Great Wolf Lodge, Chesterton, Bicester
Great Lakes UK Limited

Design & Access Statement Addendum

December 2021

This document has been prepared by EPR Architects in collaboration with the wider design team, to be read as an addendum to the original 2019 application (Application Ref. 19/02550/F (Appeal Ref: APP/C3105/W/20/3259189)).

Bay A
Proposed Typical Bay Study - Porte Cochere

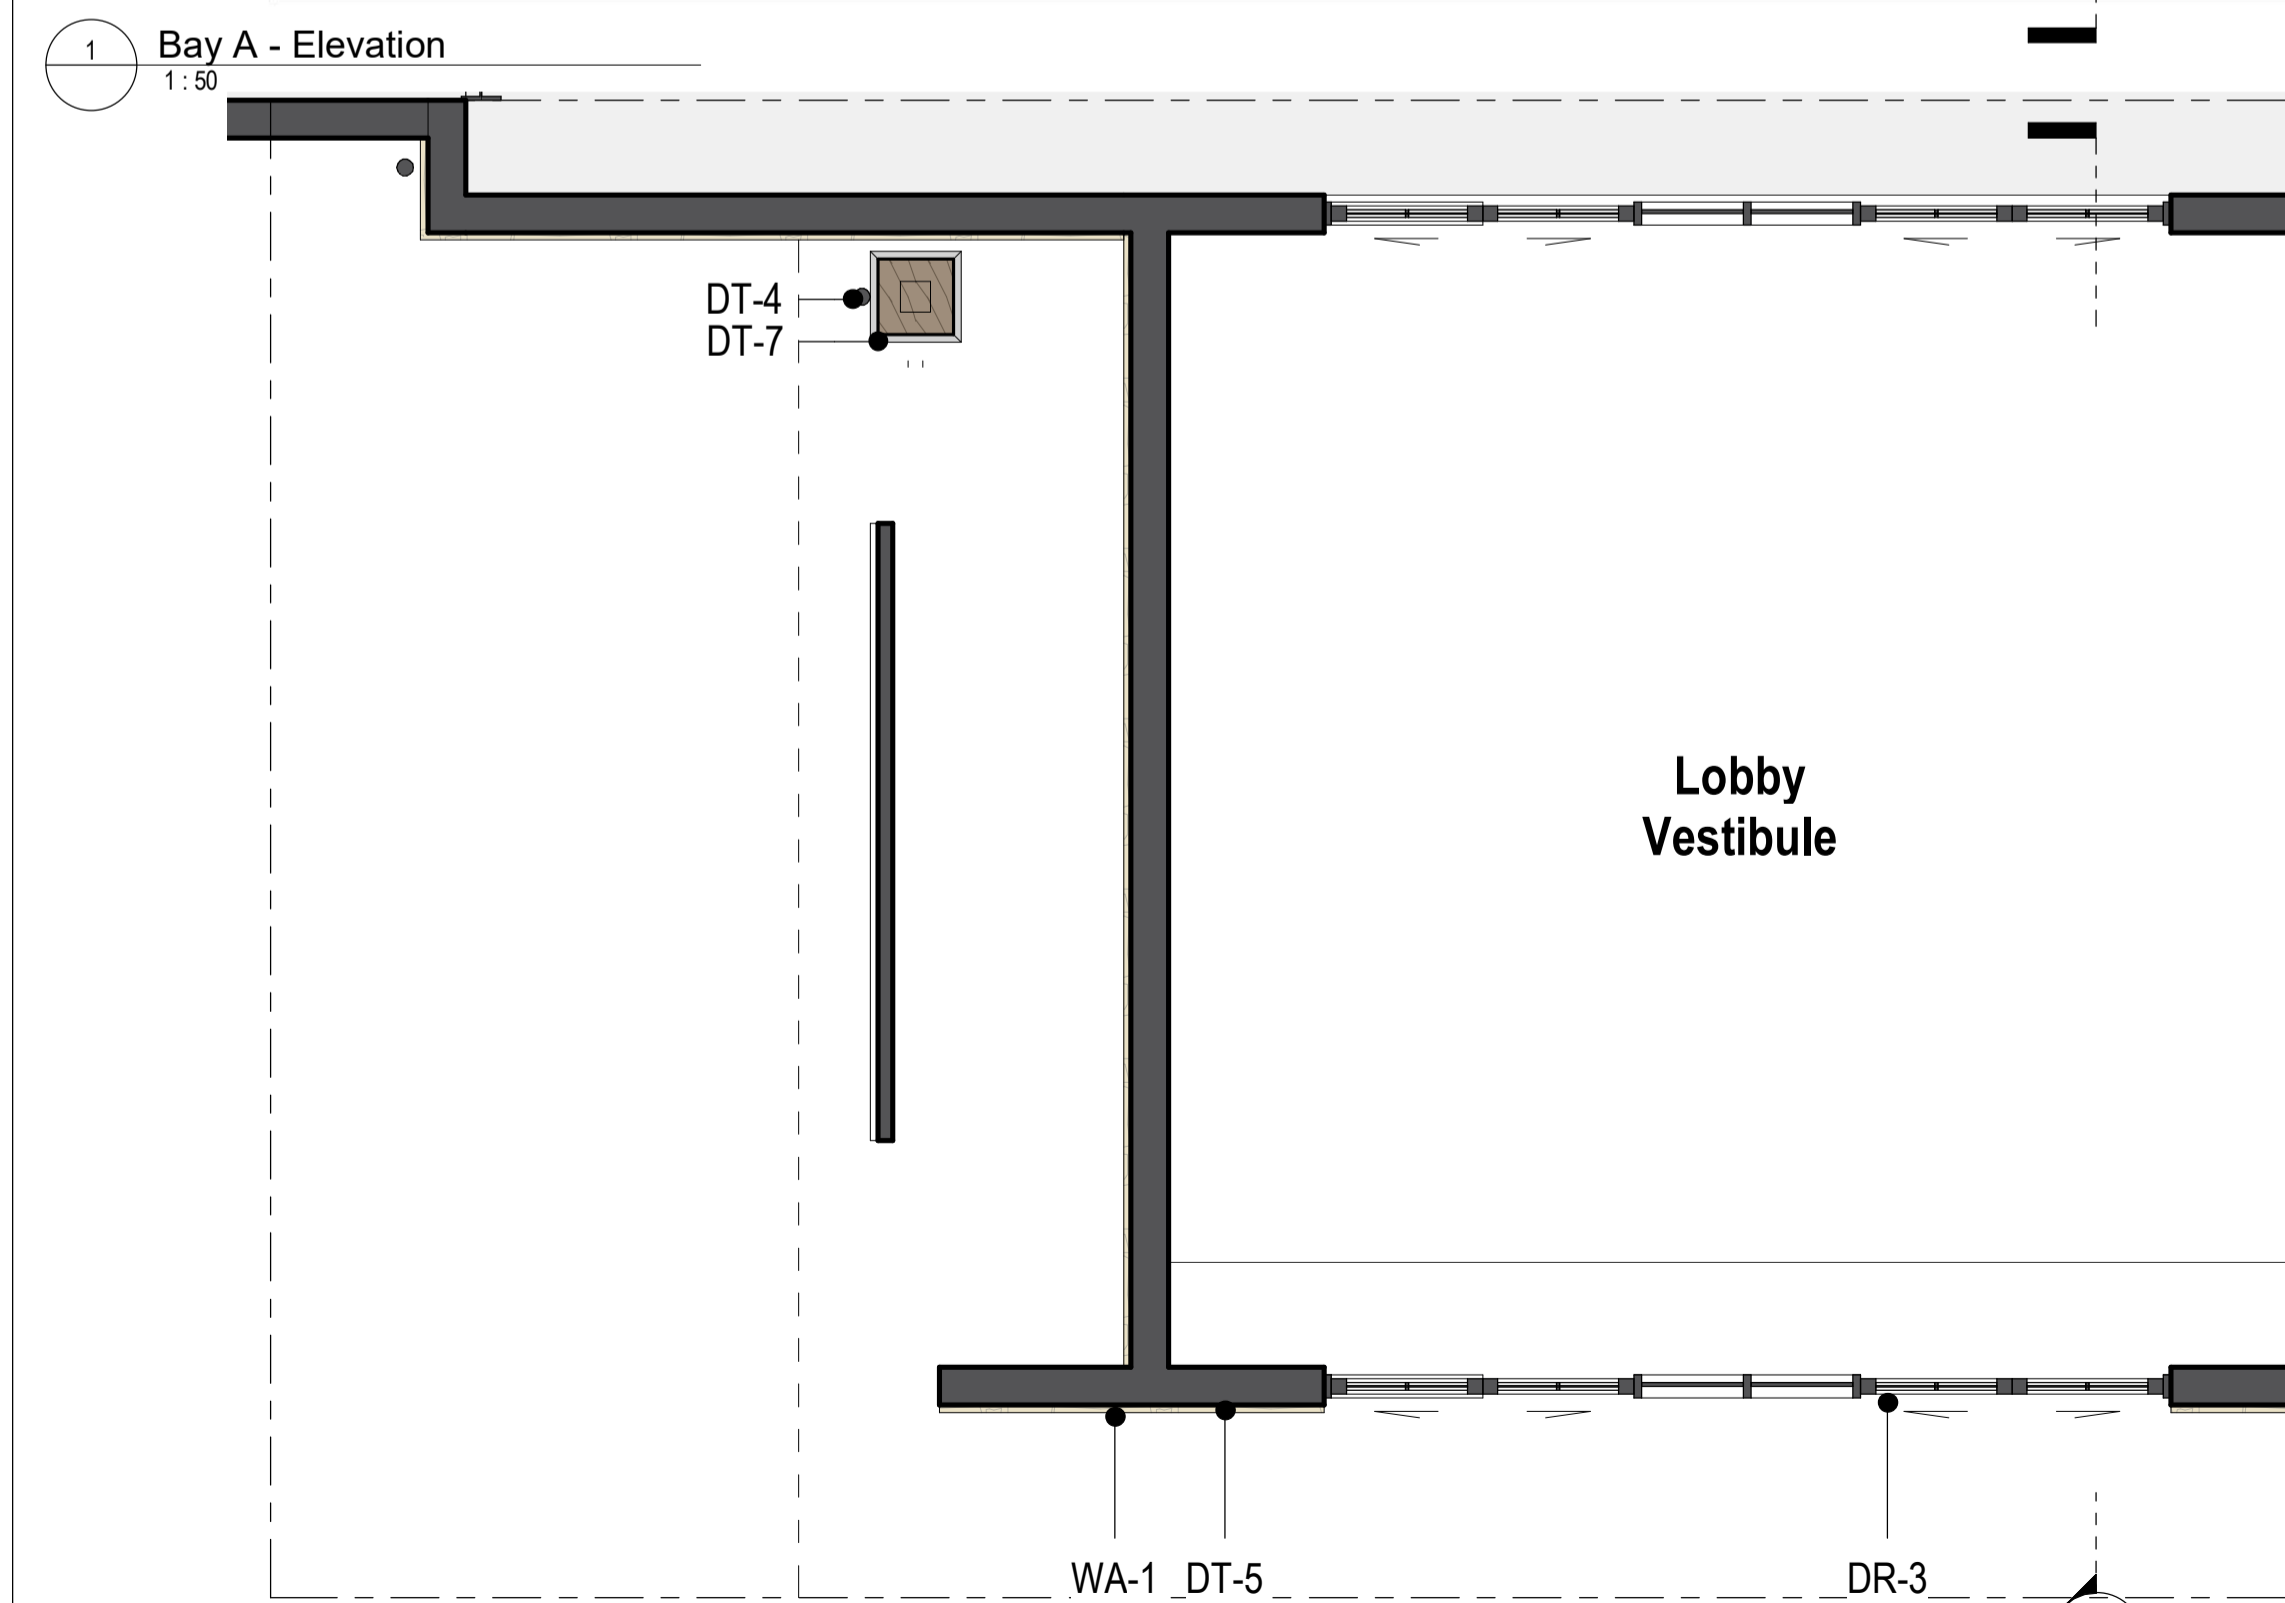
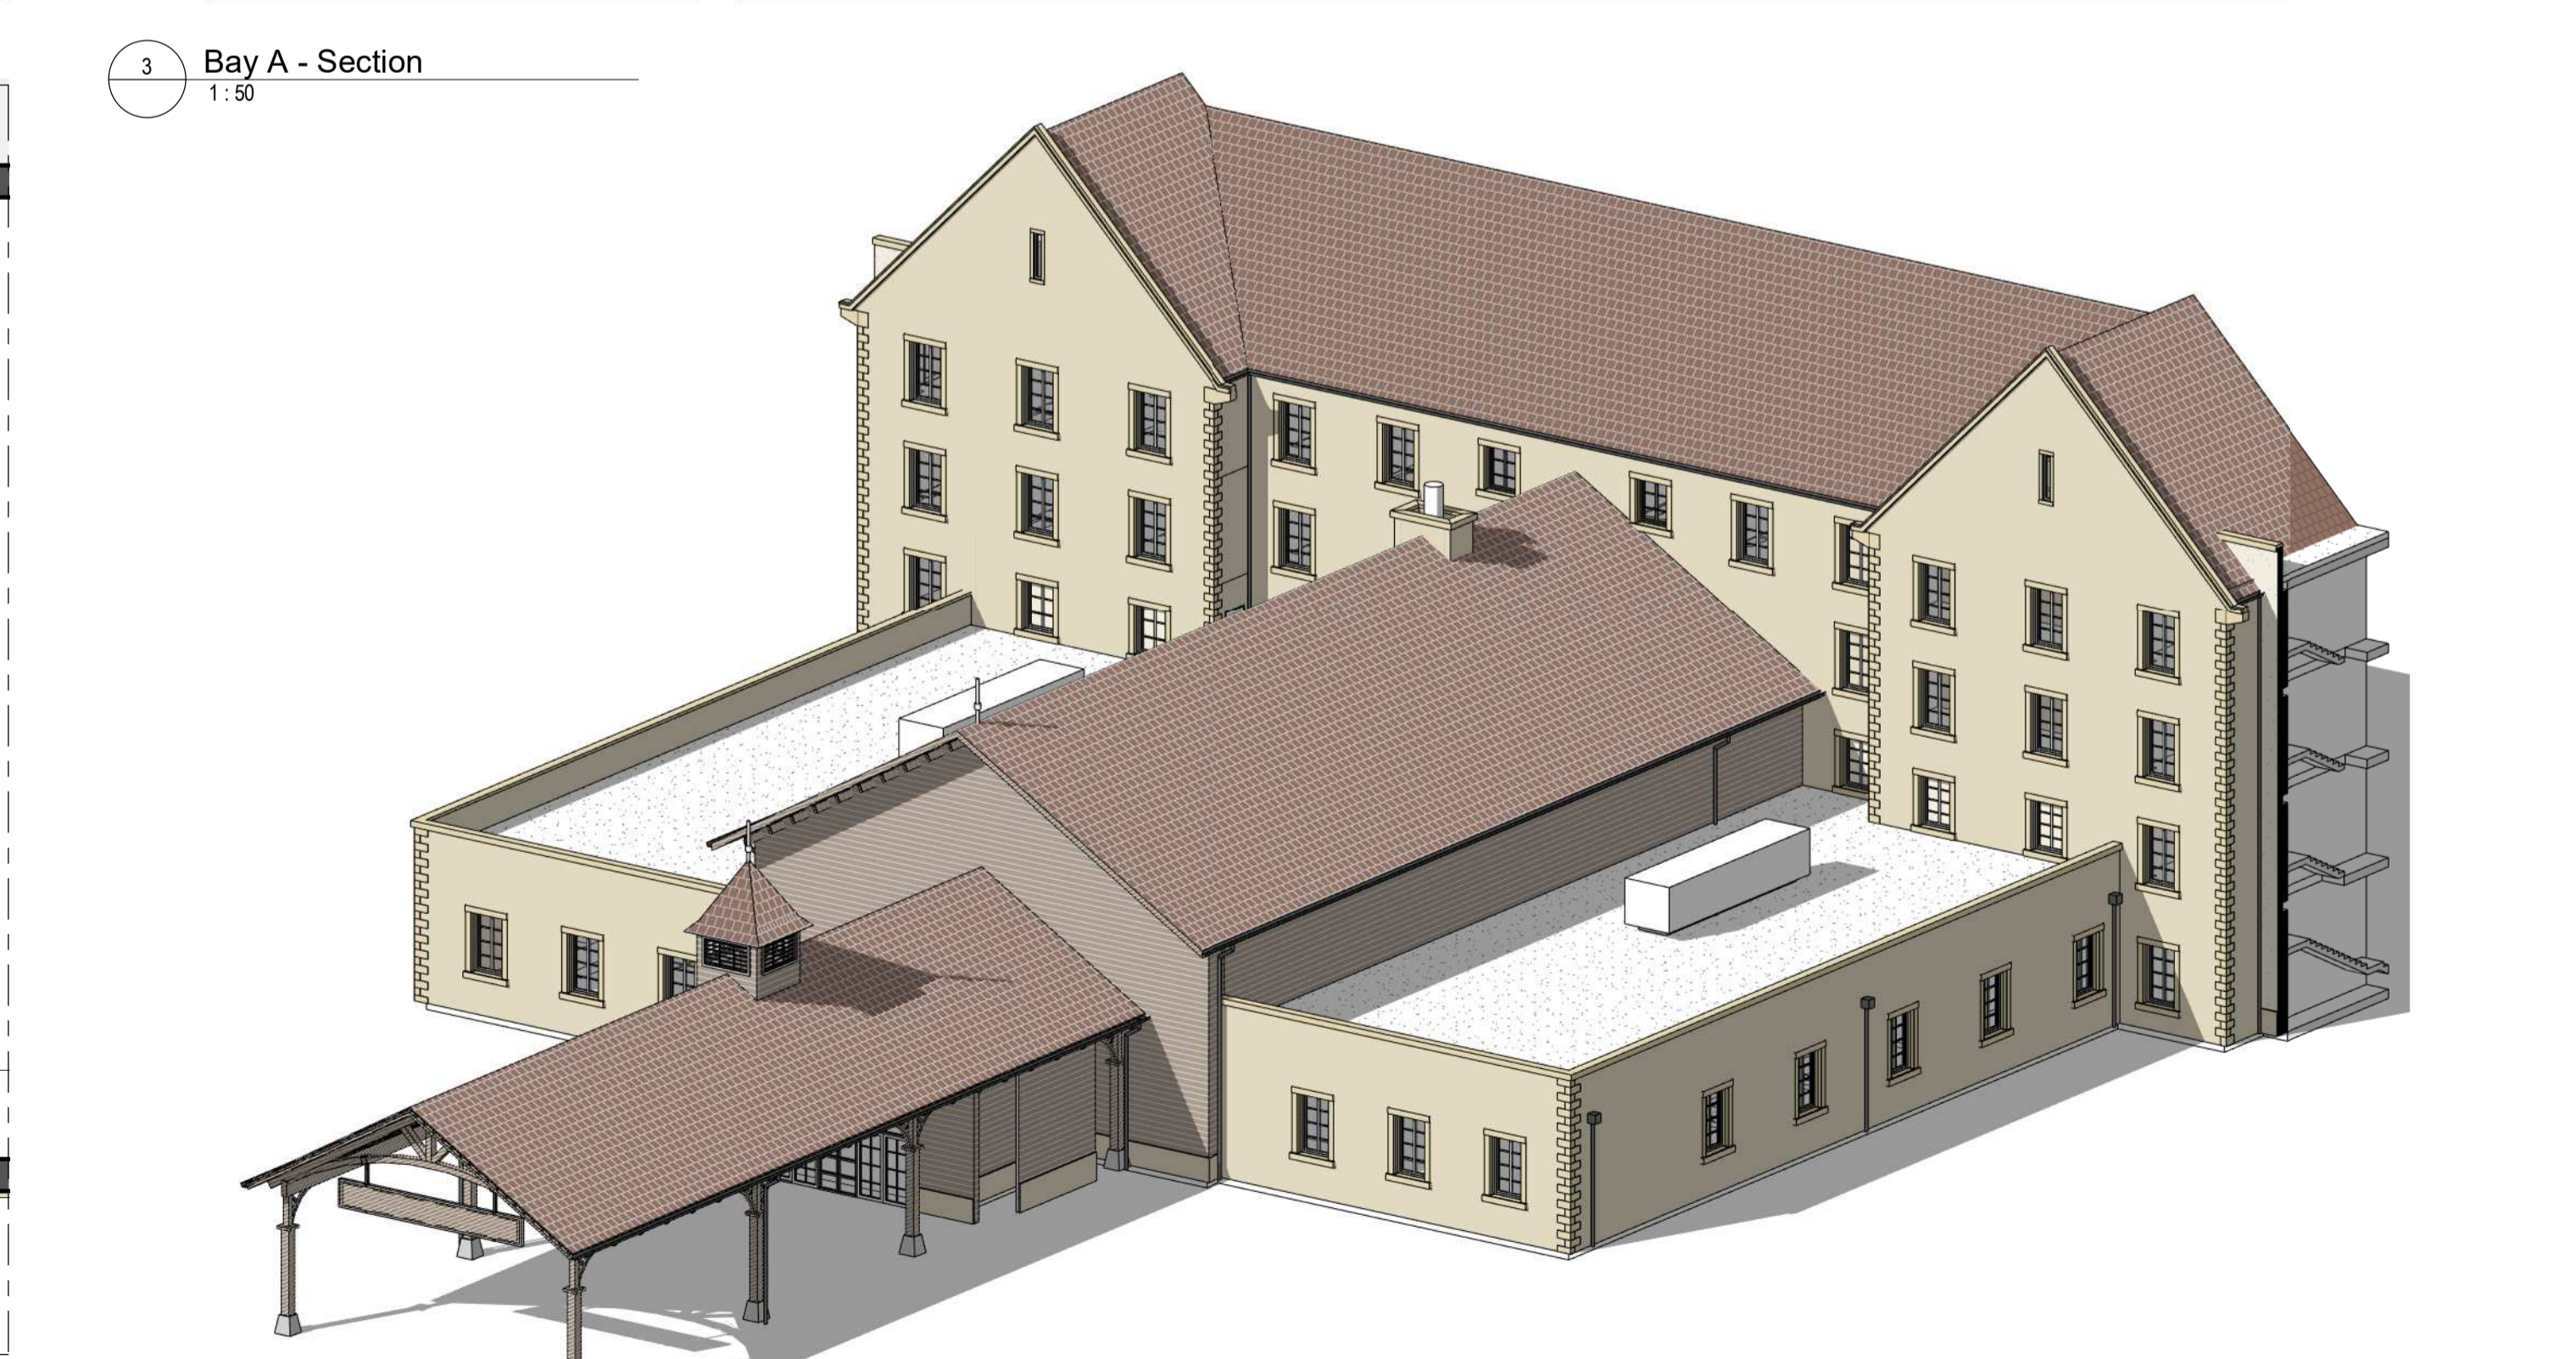
3. Extension of the Porte cochere as a result of shifting the building southwards 3.6m. Updates made to create a larger drop off/set down point for arriving guest vehicles and shuttle buses. Refer to page 13 for details.
